**APPLICATION NO:** 21/00218/FUL/ADDINF

**DESCRIPTION:** Demolition of existing buildings and erection to 2 no. replacement dwellings

**LOCATION:** Blackthorn Cottage Chawridge Lane Winkfield

CLIENT Mr & Mrs M Perry  
 PROJECT Blackthorne Cottage, Chawridge Lane Winkfield  
 DRAWING PLOT 2 - PROPOSED PLANS & ELEVATIONS  
 DATE January 2021  
 SCALE 1:100 @ A2 DRAWN P.Bonney NO 3736 / 203 REV

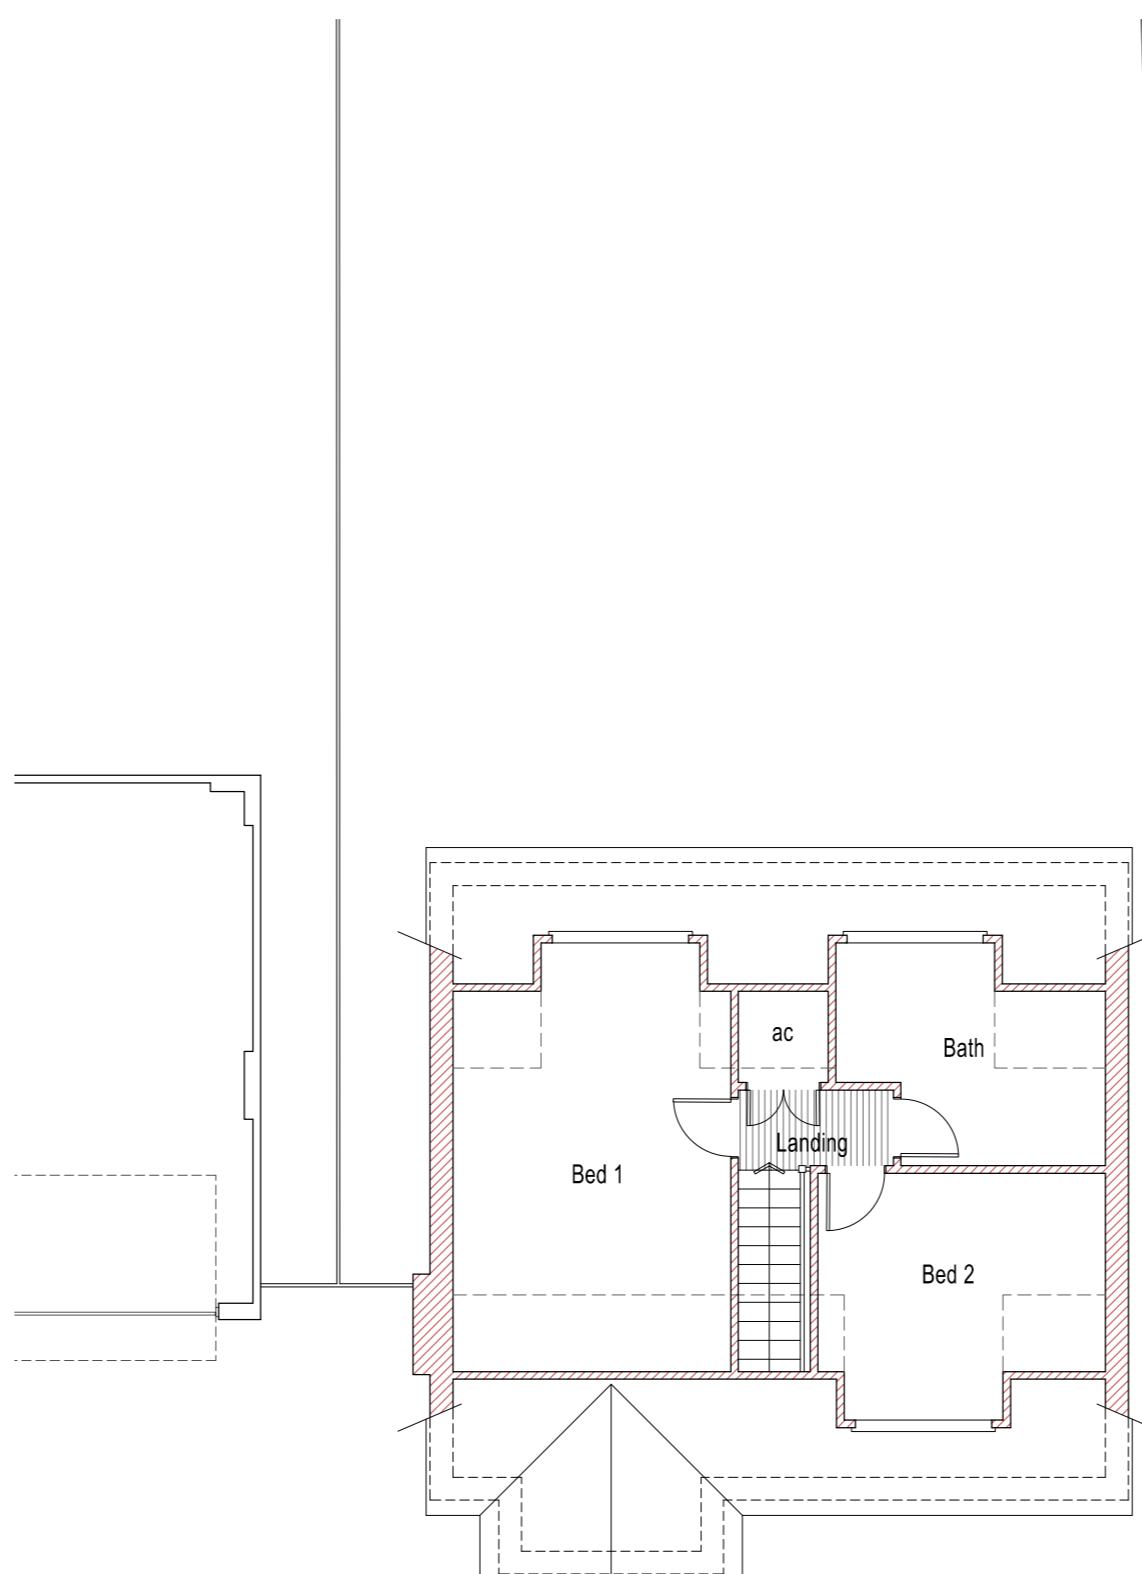
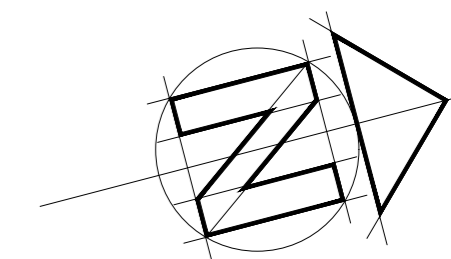
- 1 There are no roof plans for the proposed dwellings with the floor plans or the site plan. Please can you provide scaled roof plans.
